Application No: BE/92/20/DOC
Site Address: Babsham Business Centre Babsham Lane Bersted PO21 5EL
Description of works: Approval of details reserved by condition imposed under ref BE/89/19/PL relating to Condition Nos 2 - car parking spaces, 3 - acoustic assessment, 4 - mitigation & remedial strategy for reptiles, 11 - access road, 12 - bat boxes and 13 - dust control

Thank you for your internet representation made on 18th November 2020 which has been recorded as an objection with the comments as follows:

DRAWING TITLE
PROPOSED RESURFACING OF SITE ACCESS

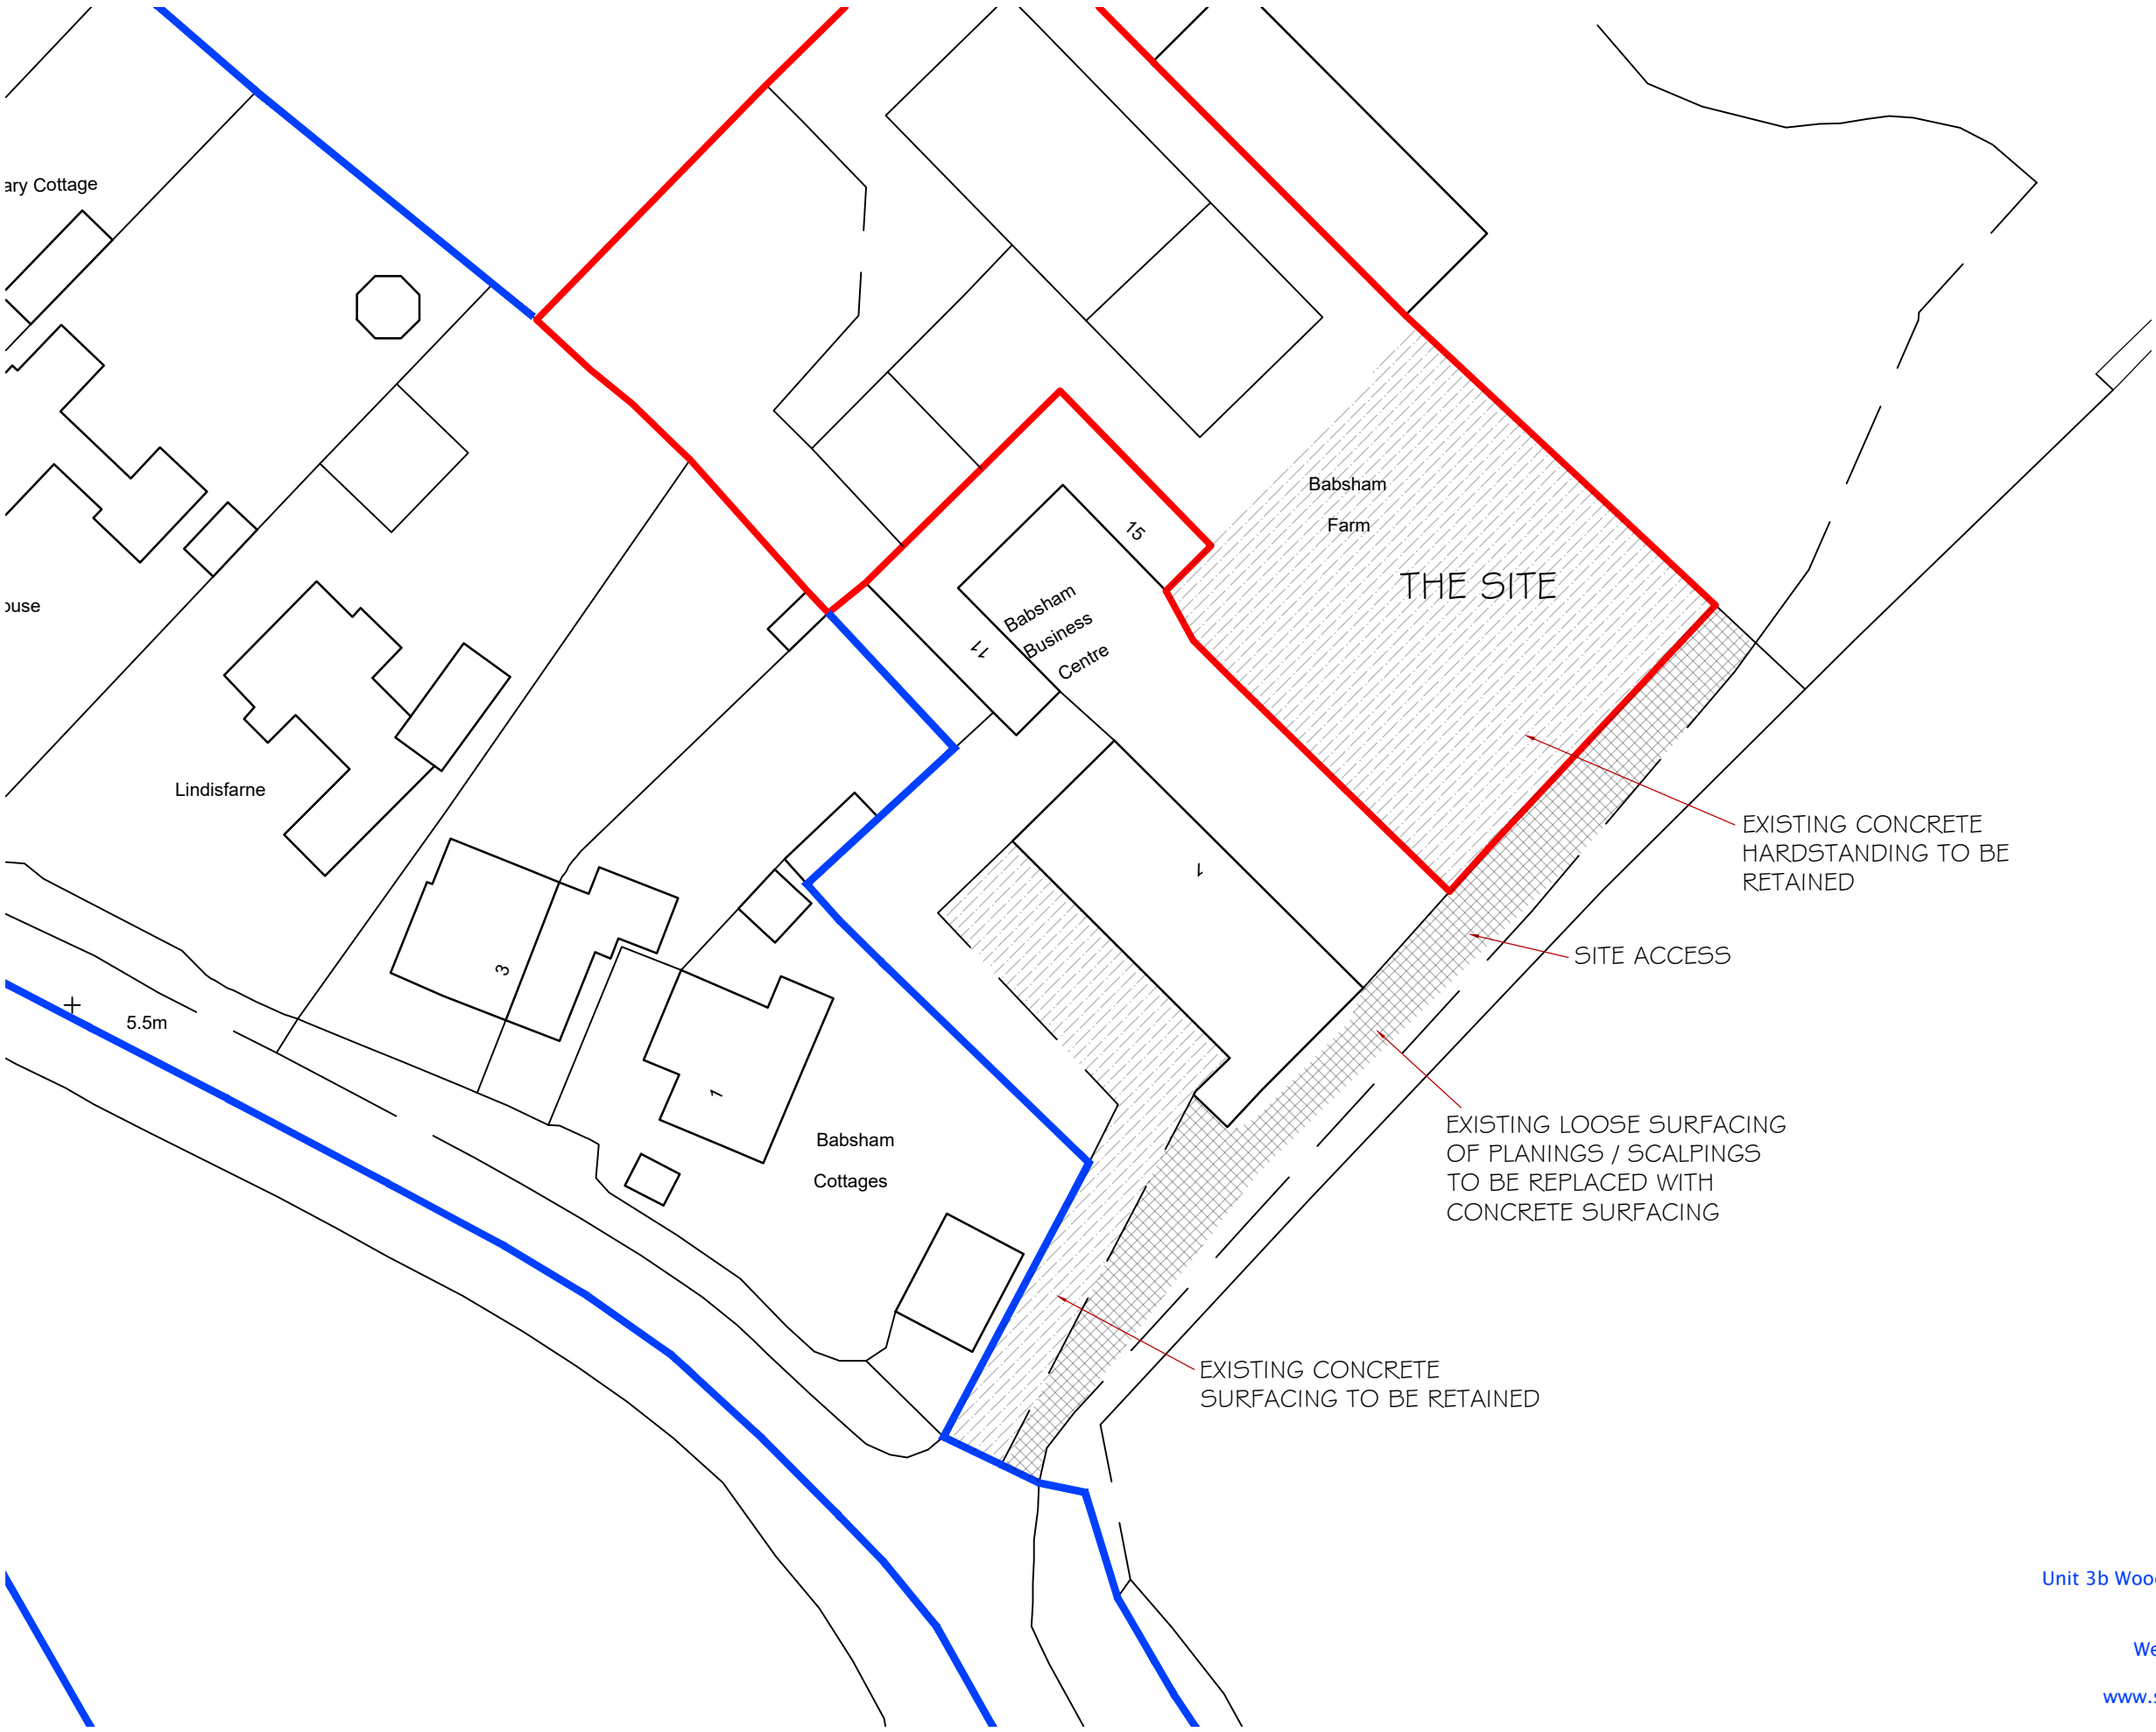
3. Access Road (condition 11) - this condition has also not been carried out in the 3 month timeline given at

the DCM. At the DCM Councillor David Edwards was very disappointed at the condition of this access road. He asked for a TSP1 Transport Assessment to be carried out but it was decided that this was not necessary. However Councillor Edwards pressed that there needed to be a scheme in place for the repair and upkeep of this road. In a letter by Mr Brown dated 21st August he mentions that this access road will be "resurfaced with concrete" however this is then contradicted two paragraphs later with "the resurfacing of the existing unmade section of road with tarmac- ". We believe that there is a requirement for a management plan for the upkeep of the road as it is used on a daily basis by HGVs at 32tn (laden weight) together with vans and cars.

Figure 6: L_{A90} statistical analysis including data from when the site was in use

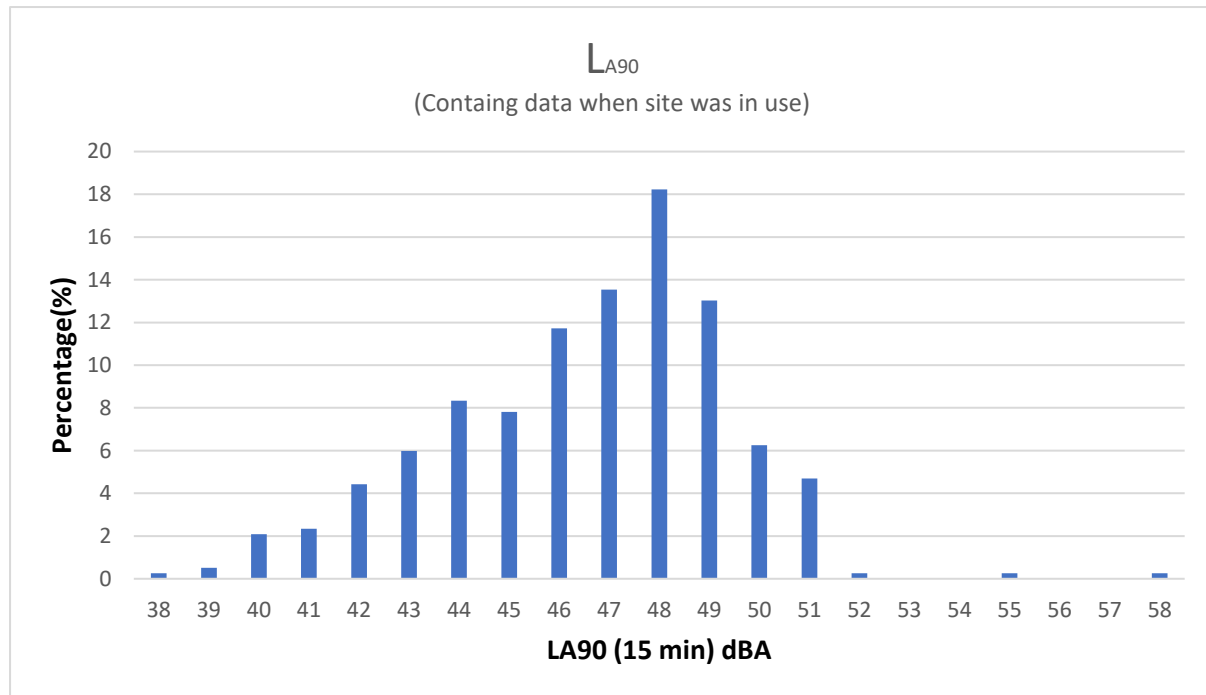
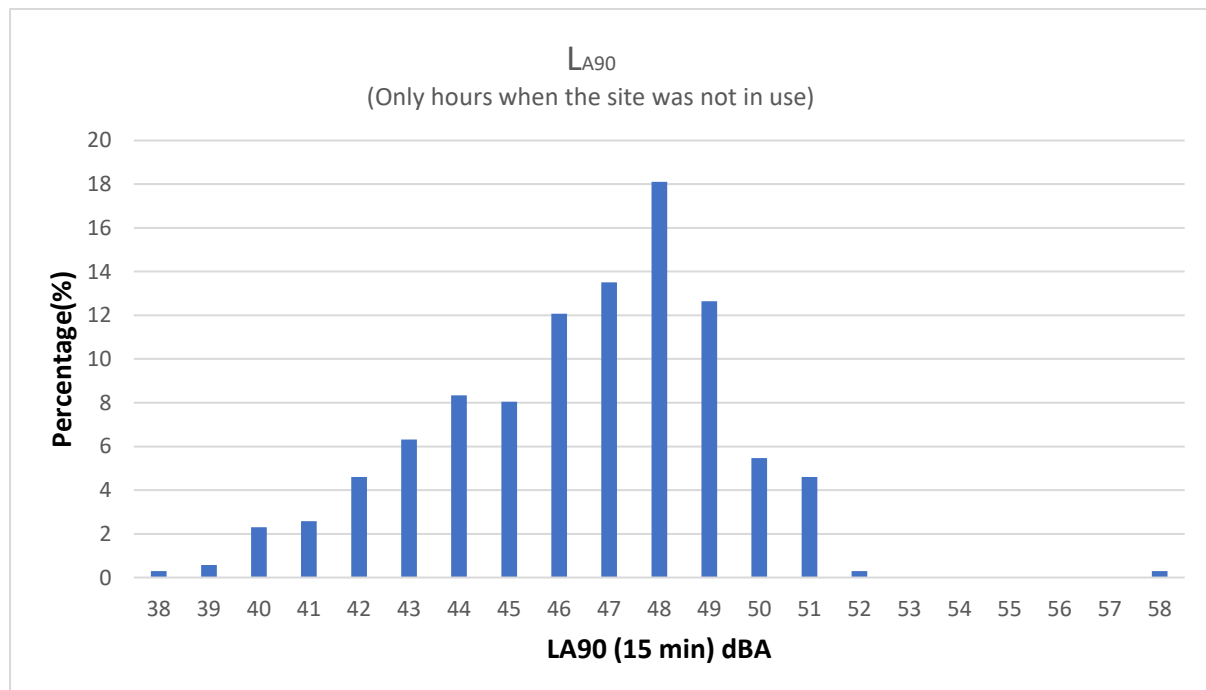
Therefore we find the report misleading. We would like to point out that the obvious dominant sound level of undefined equipment is a generator used by the company next door.

Figure 12: Worst-case house noise model

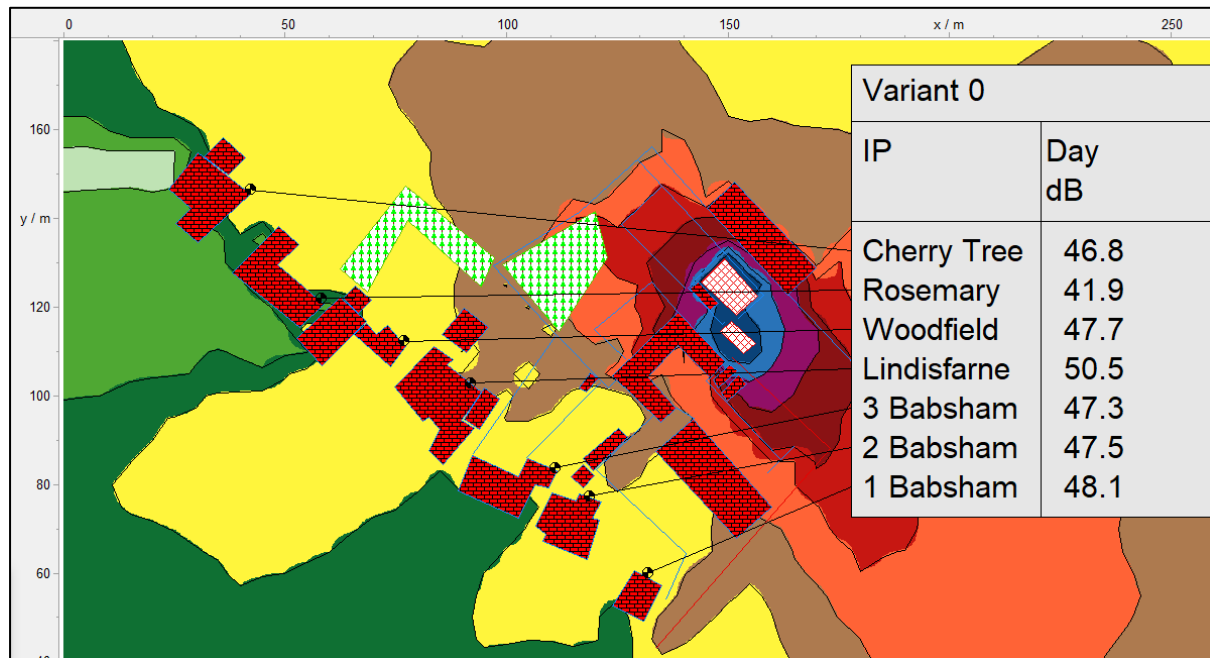
1. Acoustic Assessment (condition 3) - this was not carried out in the required 3 month timeline given at the DCM on 3rd June 2020. However the results are incorrect inasmuch as the colour document 'figure 12' shows the residential properties incorrectly numbered/named. "1 Babsham" is a garage, "2 Babsham" is 1 Babsham Farm Cottages, "3 Babsham" is numbers 2 and 3 Babsham Farm Cottages. Sunset is not shown which is next door to Rosemary Cottage.
